Our Case Number: ABP-316119-23
Planning Authority Reference Number:

Re: DART+ South West Electrified Heavy Railway Order - Hazelhatch & Celbridge Station to Heuston Station, and Hesuton Station to Glasnevin
County Dublin and County Kildare

Dart + South West Electrified Railway Order 2023

ABP case number 308826

KHYBER PASS FOOTBRIDGE (OBC5) RECONSTRUCT BRIDGE.

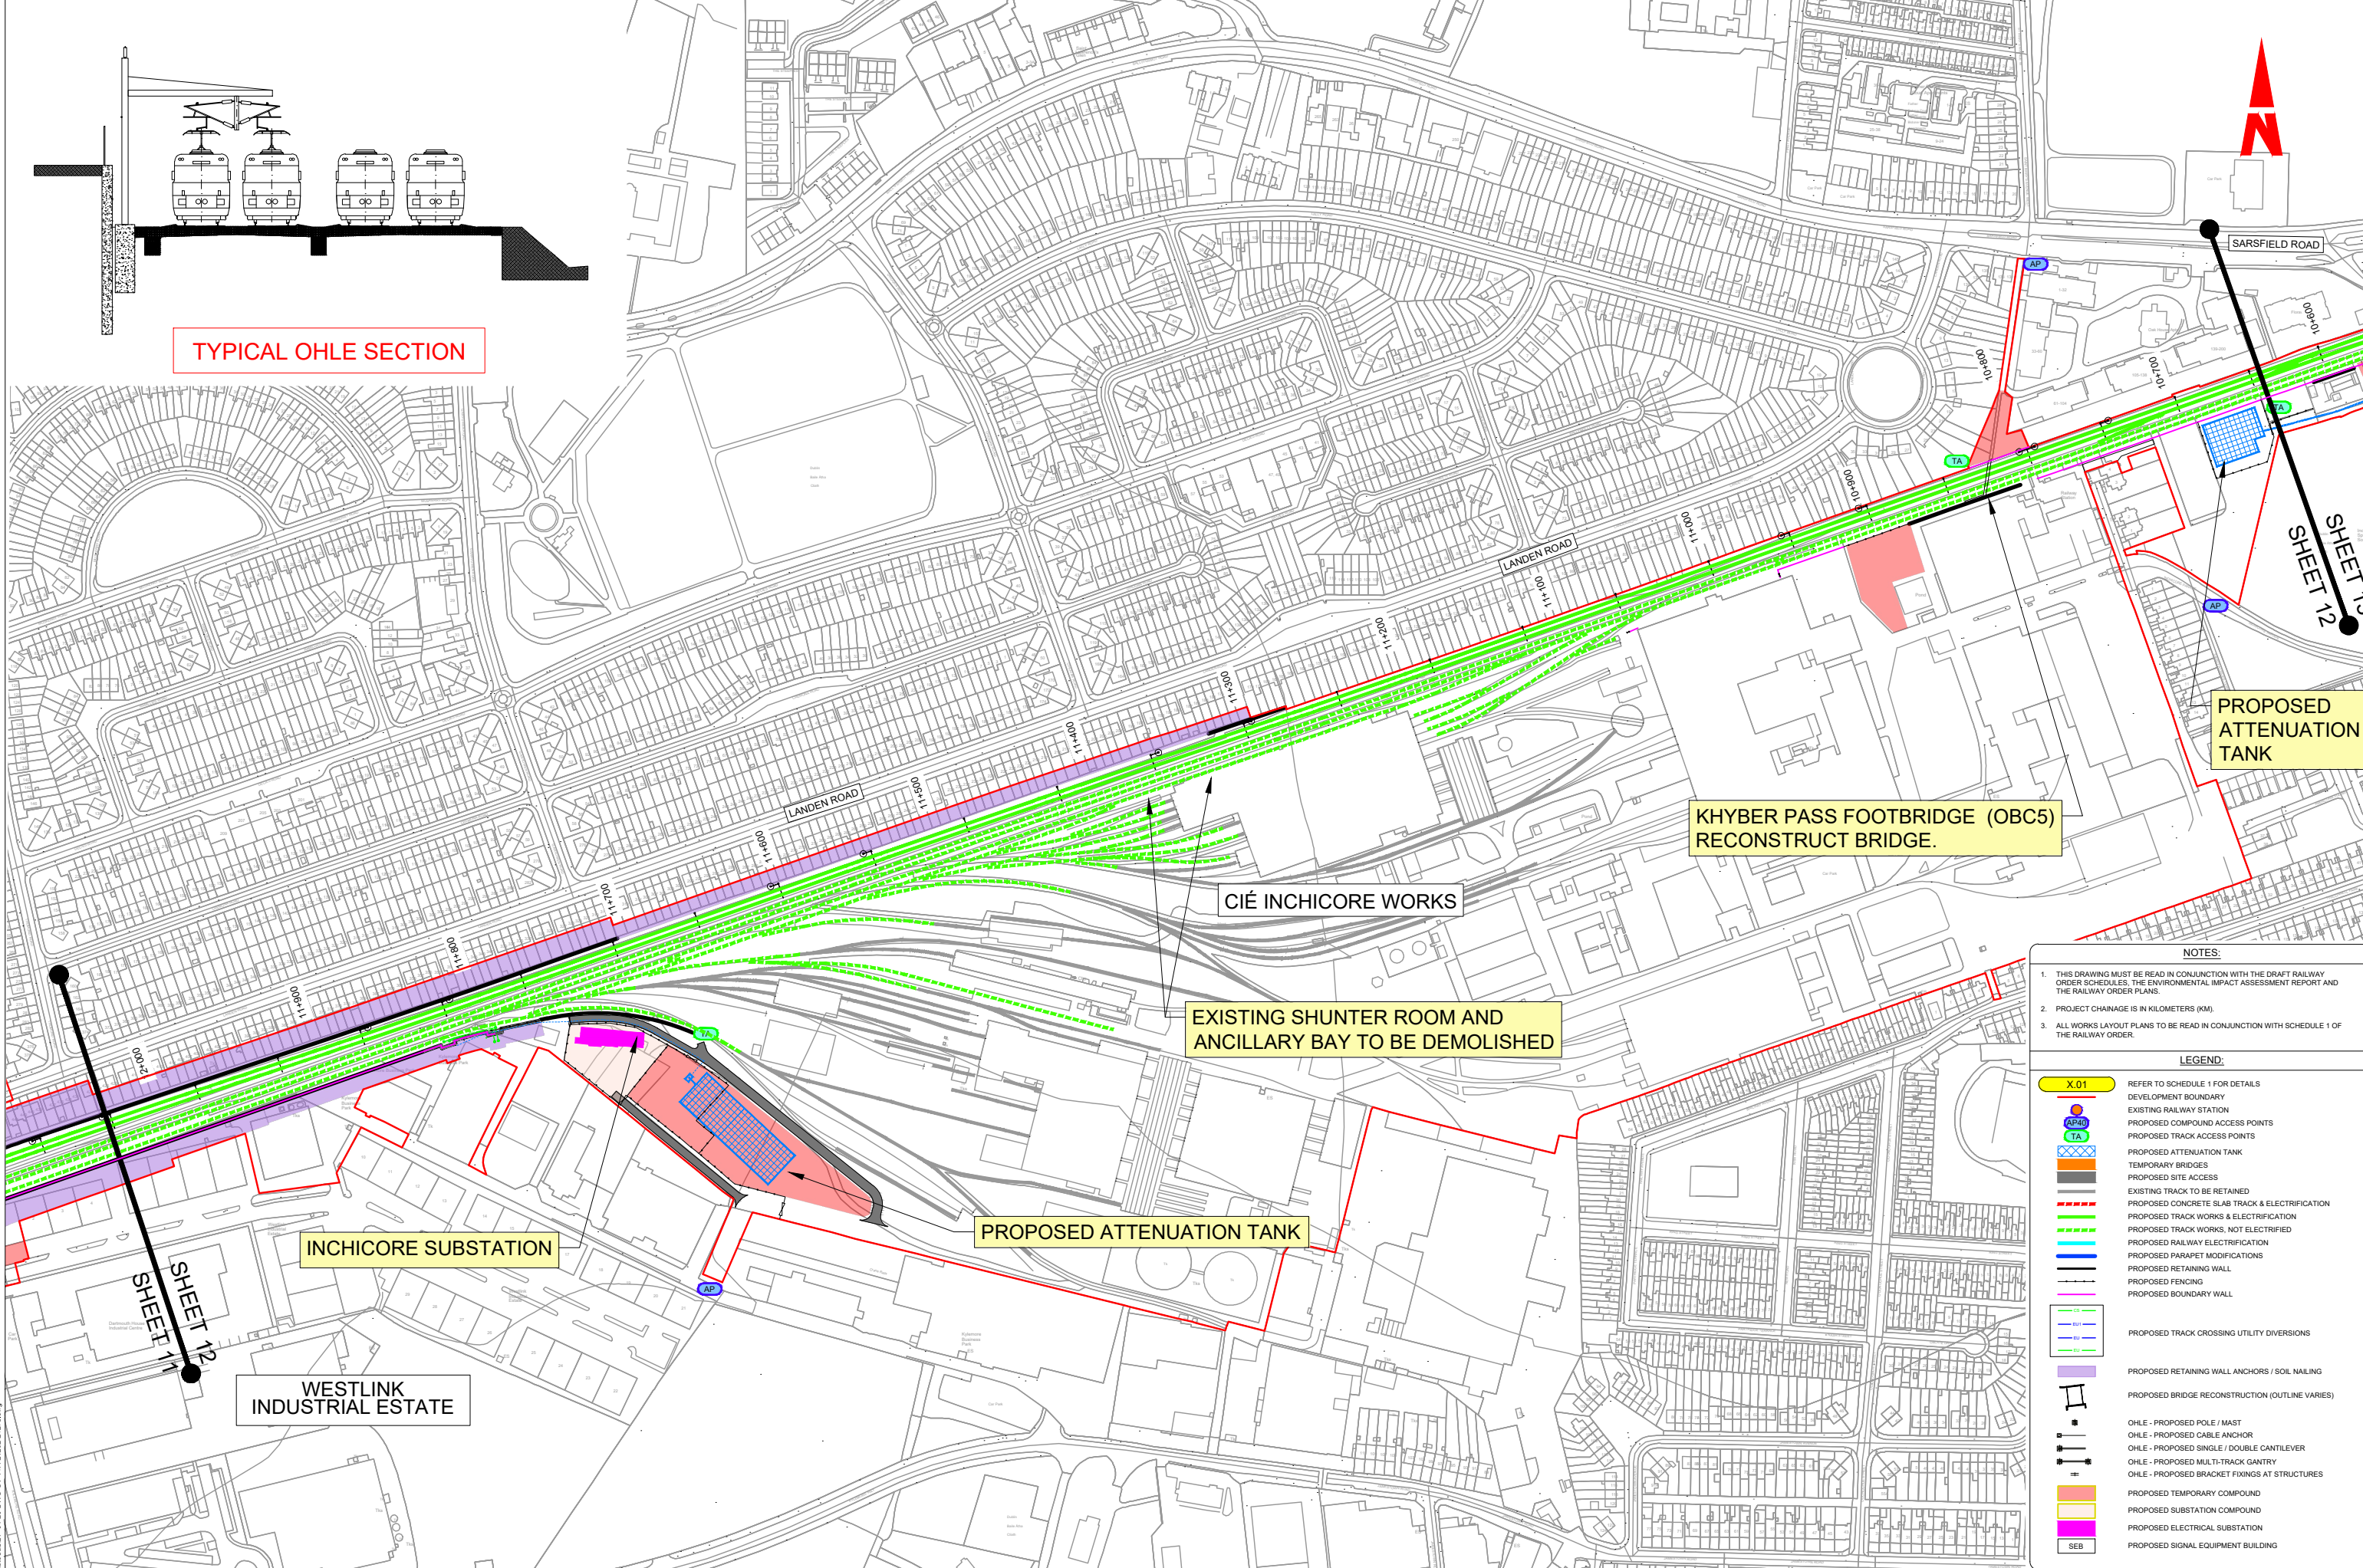
- The proposed reconstruction of the bridge ref (OBC5) at the Kybher pass will create a situation that will impact our property from a **privacy** point of view. The current bridge does not overlook our property but if the newly planned bridge is constructed it will pose an **overbearing** impact to our property and impact the **privacy** of our home. Alternatively I would like to suggest that

when the bridge is taken down for the proposed works that it is left down and removed completely, and the route that CIE workers will be using for the duration of this works can become the new entrance to CIE, why impact the properties for myself and my neighbours when there are ways around this to accommodate everyone.

- The proposed widening of the Kybher pass lane way will involve the acquisition of part of our neighbours property. The removal of the boundary wall will impact our property from a **security** point of view as it will expose our property to potential intruders/trespassers during the demolition/construction period of the project.

- The removal of the shrubbery and the trimming back of our neighbours mature trees will also expose our home to the Seven Oaks apartments which will impact our **privacy**. Currently the trees and shrubbery provide us with privacy from the apartment complex .If the boundary wall and the shrubbery are removed the apartments will become an **overbearing** impact to our property/home.

- The existing laneway was originally extended eastwards to provide access to the rear of the Seven Oaks apartment complex circa 2003. The boundary to our property is part of the original west boundary wall that runs through from Sarsfield road.
There is currently a strip of unused ground (ref 18832 T 302 B) in a derelict condition that is part of the seven oaks apartment complex and could be used to facilitate the widening of the kybher pass laneway and the repositioning of the footbridge.

- If this option was used it would avoid the removal of the west boundary wall and the destruction to our property and the other properties that will be impacted by the removal of the existing west boundary wall at the kybher pass.
